# Dean Moor Solar Farm

## Draft Statement of Common Ground with Cumberland Council

26 August 2025  
Prepared by: Stantec UK Ltd  
PINS Ref: EN010155  
Document Ref: D2.8  
Deadline 2  
Revision: 1

Drawing file: published-documents / EN010155-000051-6.2 ES Figure 2.1 Cumulative Schemes within 10km of the Order Limits.pdf

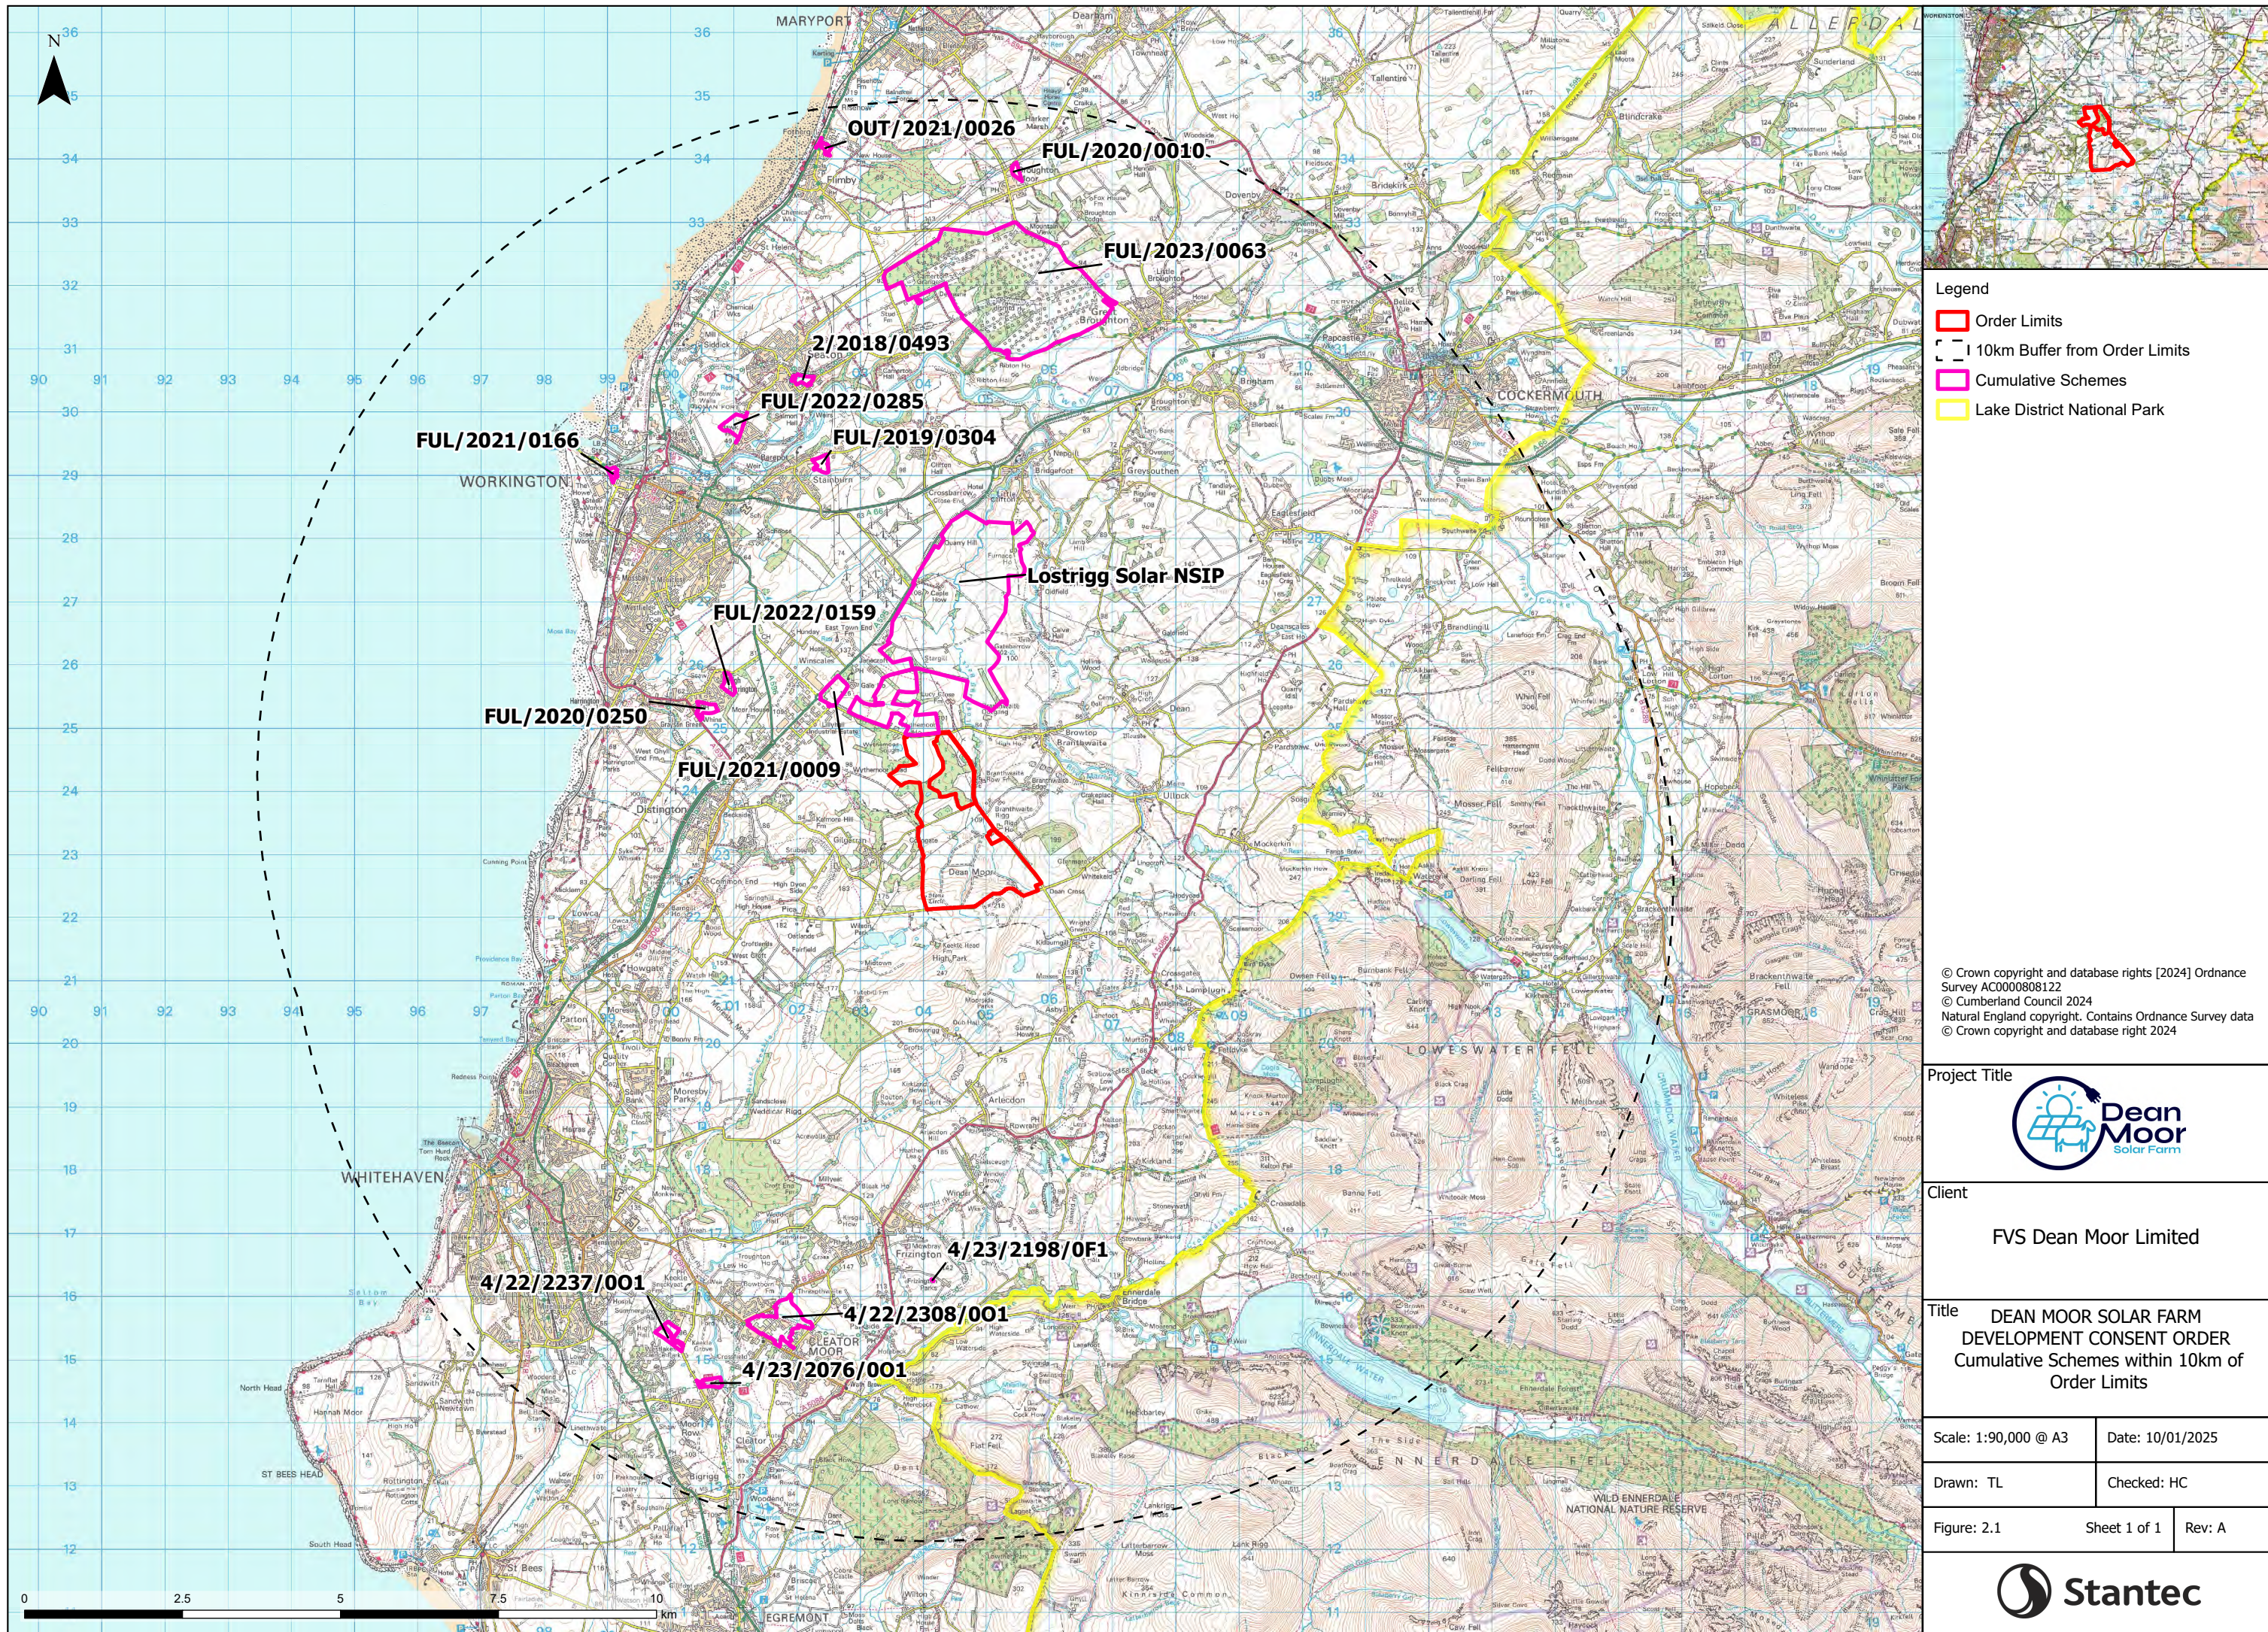
CC.LPA. 7	Cumulative Effects	<p>The Applicant has made previous requests to the Council for comment on the proposed list of cumulative schemes set out in Table 2.6, and used to inform the cumulative assessment throughout the process of the preparation of the ES, prior to the submission of the DCO application.</p> <p>No comments were previously made by the Council suggesting an incomplete list as part of the PEIR. A response to the query was received on 14 August 2025. Given the number of additional schemes (approximately 30) requested by the Council for consideration in its response,</p>	<i>The Council sent the Applicant an updated list of sites on 14 August 2025, which the Applicant is currently considering</i>	Ch2 EIA Methodology <a href="#">[APP-033]</a> ES technical chapters 6-10 <a href="#">[APP-037 - 041]</a> ES Fig 2.1 Cumulative Schemes within 10km of the Order Limits <a href="#">[APP-044]</a>

Ref	Topic	Applicant Position	Cumberland Council Position	Application Ref
		<p>the Applicant will provide a more detailed consideration after Deadline 2.</p> <p>However, at this stage following an initial review, these schemes are not anticipated to alter the assessment of cumulative effects in the ES. .</p>		
CC.LPA. 8	Planning history of the Site	<p>The Applicant considers that the relevant planning history of the Site is set out within section 2.3 of the Planning Statement, and that the consideration of previous uses of the Site have informed the technical environmental assessments where appropriate, for example in consideration of the legacy of coal mining within the Site.</p>	<p><i>It is anticipated that the Council will provide a position on the planning history of the Site within the Local Impact Report. No comments have been raised in relation to planning history to-date.</i></p>	<p>Planning Statement [<a href="#">AS-010</a>]</p>
